## WEST SUSSEX COUNTY COUNCIL CONSULTATION

| <b>FROM:</b>                    | WSCC - Highways Authority                                                                                                                                                                                                                                                                            |
| <b>LOCATION:</b>                | Land adjacent to Sefter School House<br>Sefter Road<br>Bognor Regis<br>PO21 3EE                                                                                                                                                                                                                      |
| <b>SUBJECT:</b>                 | P/116/19/OUT<br><br>Outline application with all matters reserved for the erection of 4 No. semi-detached 3-bedroom houses & 2 No. detached 4-bedroom houses with associated access, parking & gardens. This application is a Departure from the Development Plan.<br><br>More information received. |

Proposed Site Access Arrangements

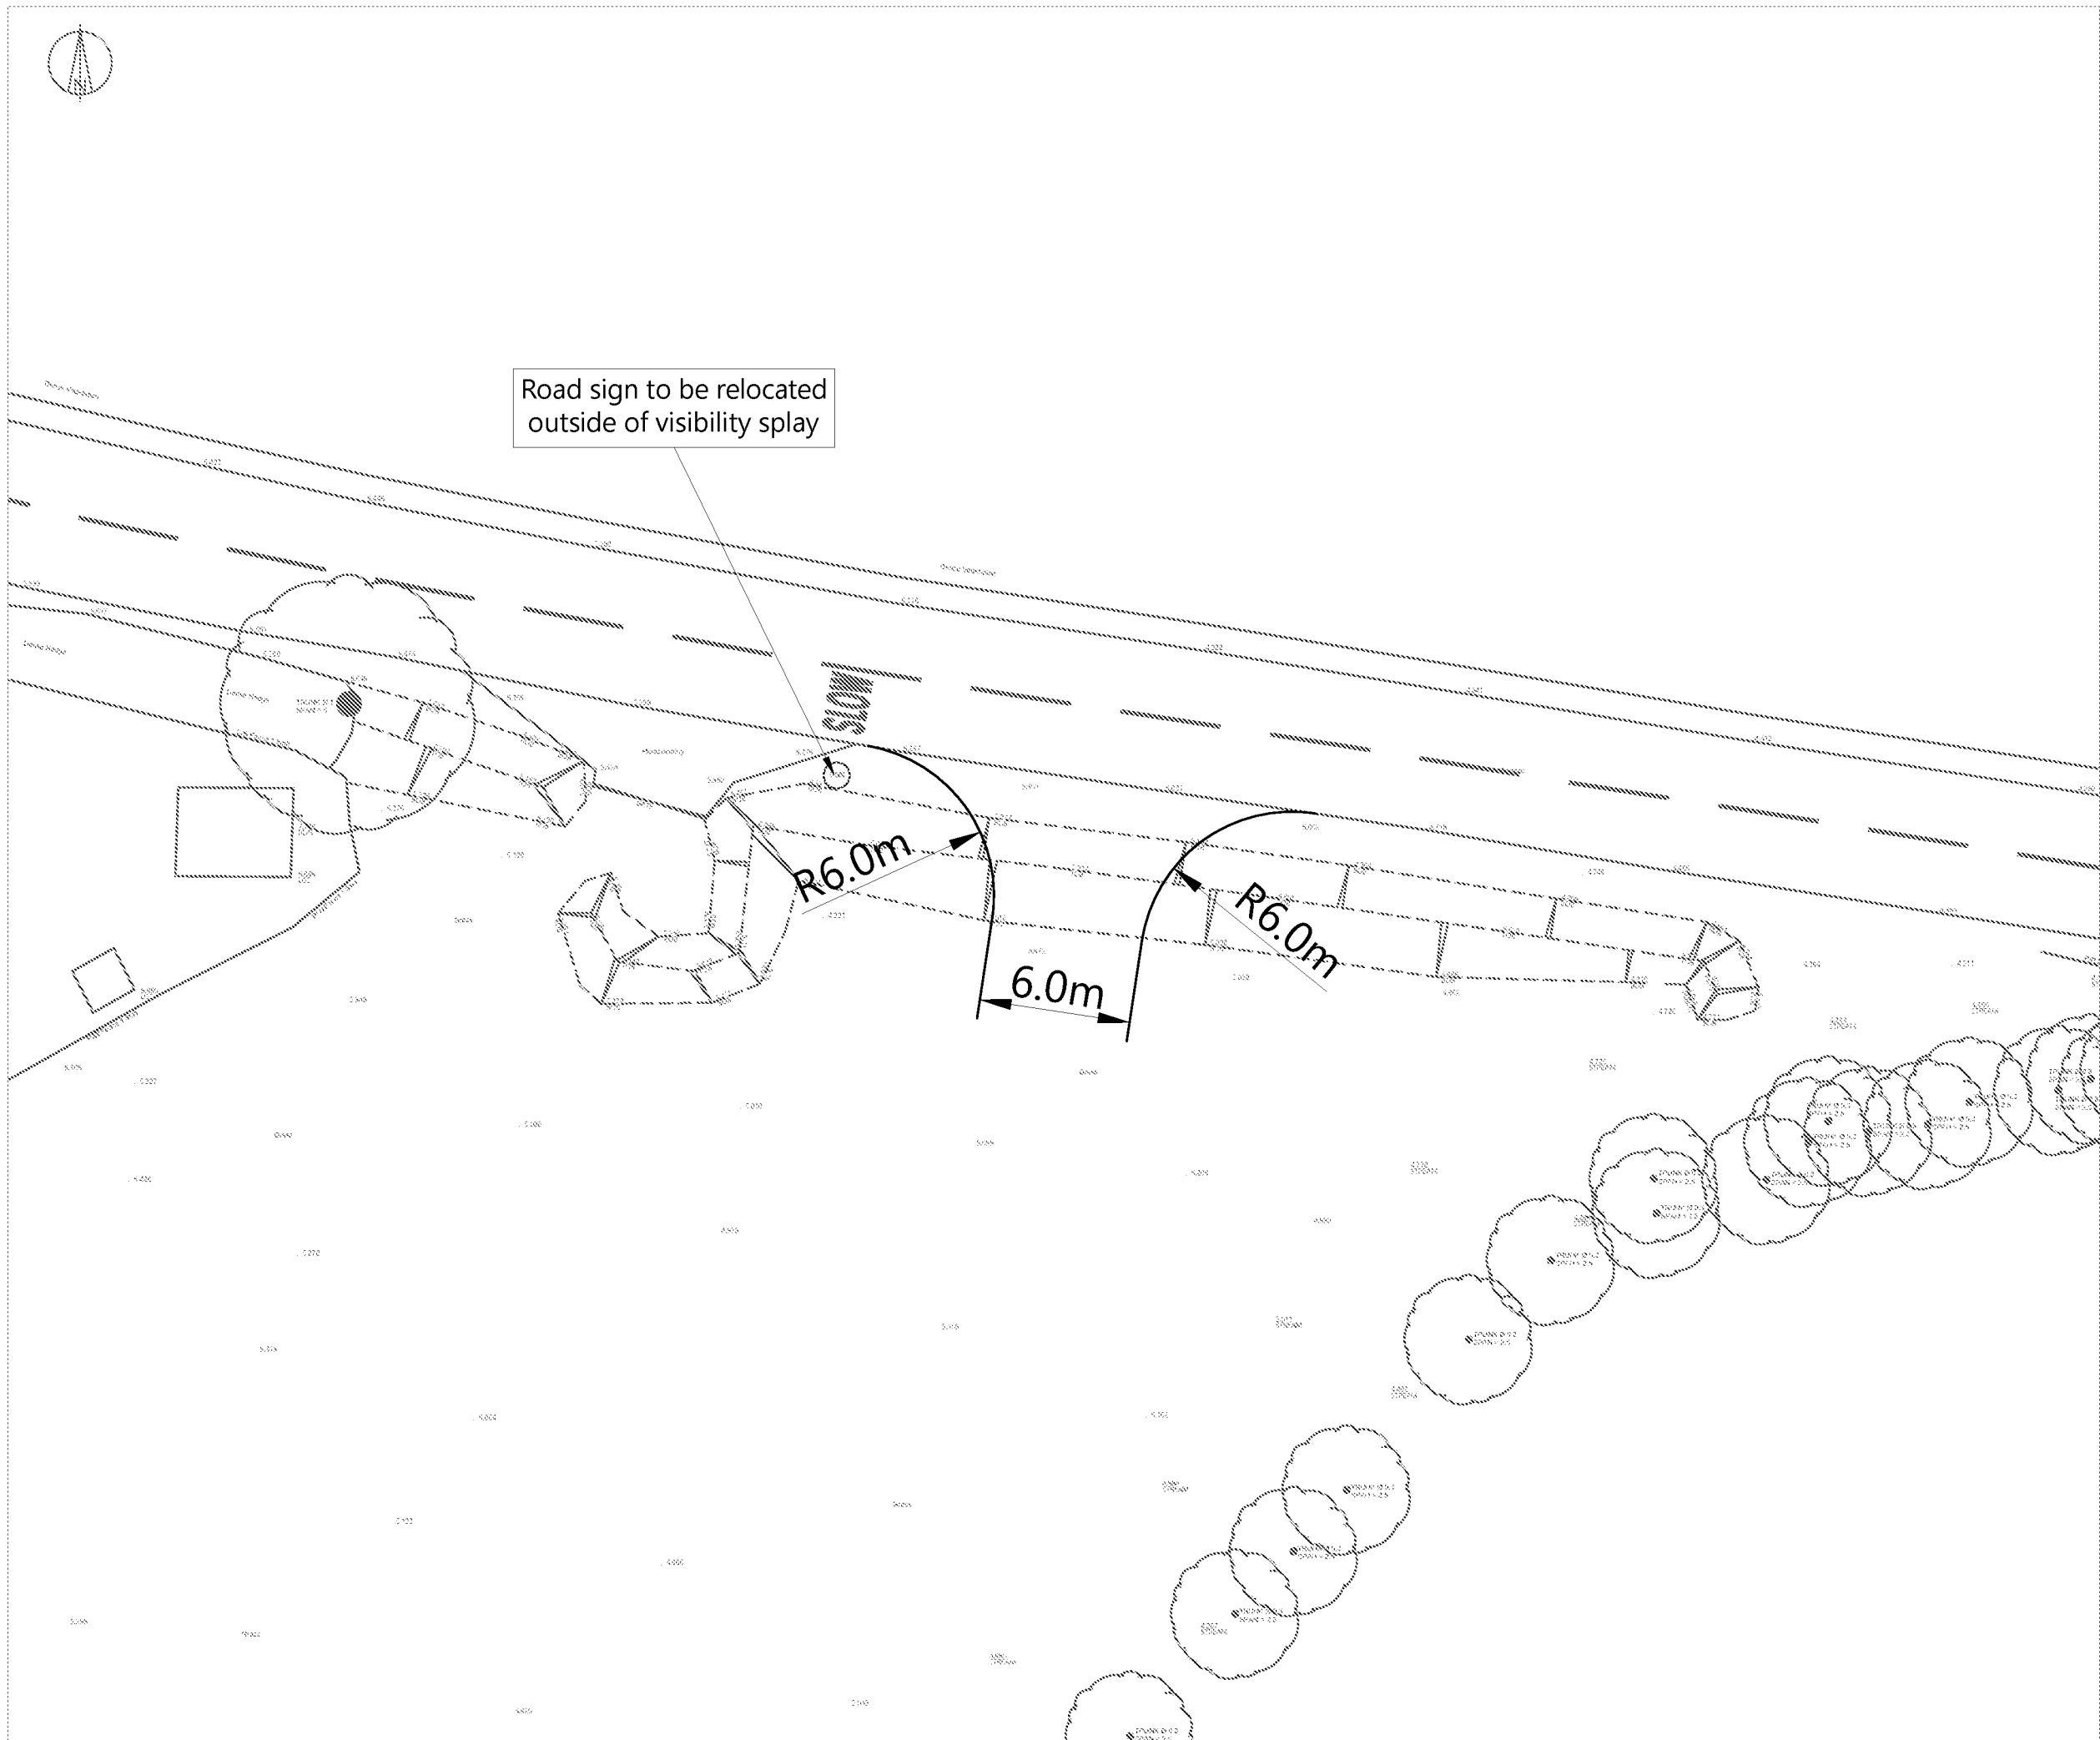
The applicant has supplied kerb radii details showing 6 metres and an access width of 6 metres. Tracking has been supplied showing a mixture of vehicles including a worse case scenario of a refuse truck. The LHA are satisfied with these details.

Visibility Splays of Proposed Site Access

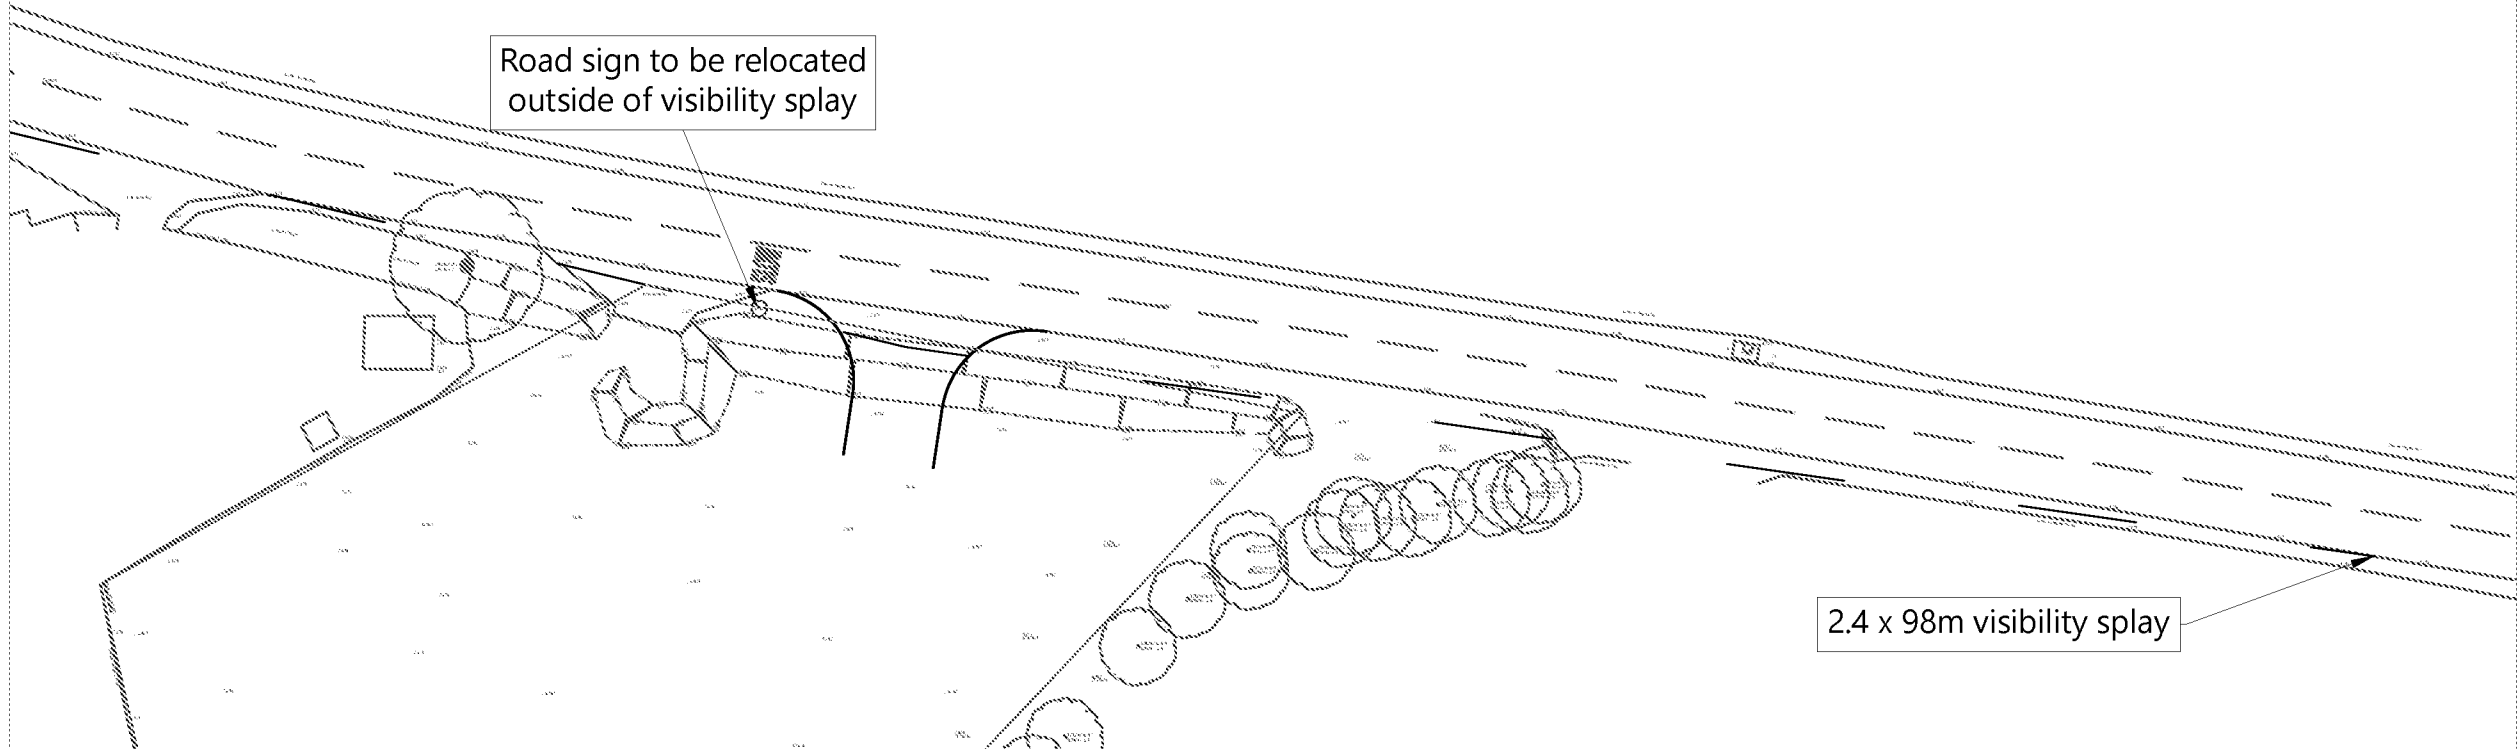
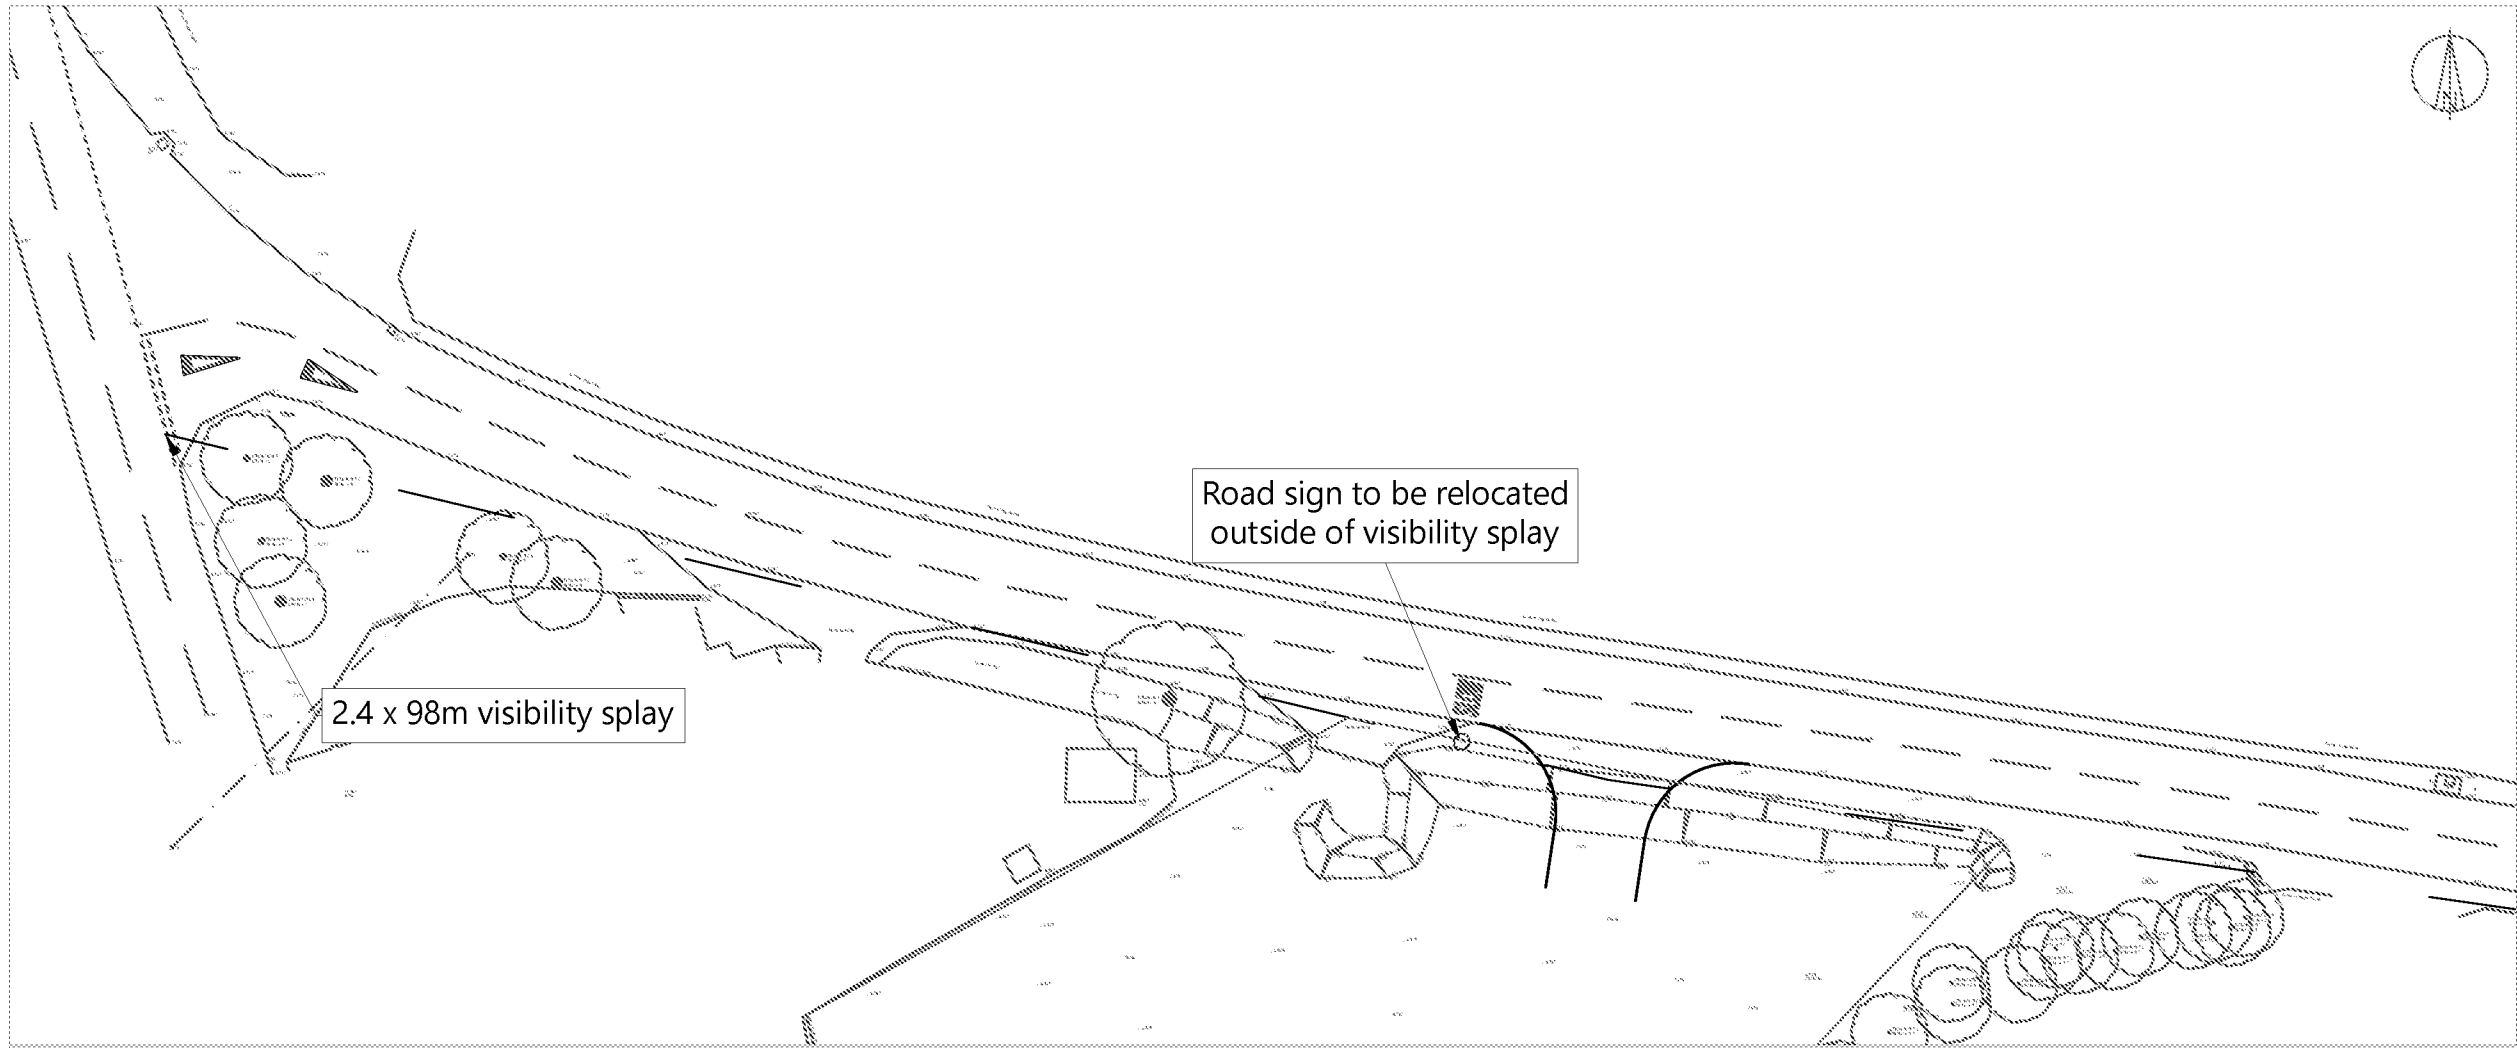
The applicant has supplied visibility splays per these road speeds 94 & 120 metres. The LHA are satisfied with these details.

The use of the access shall not commence until visibility splays of 2.4 x 94 metres and 2.4 x 120 metres have been provided at the proposed site vehicular access onto Sefton Road in accordance with plans and details submitted to the Local Planning Authority. The splays shall be maintained and kept free of all obstructions over a height of 0.6 metre above adjoining carriageway level or as otherwise agreed.
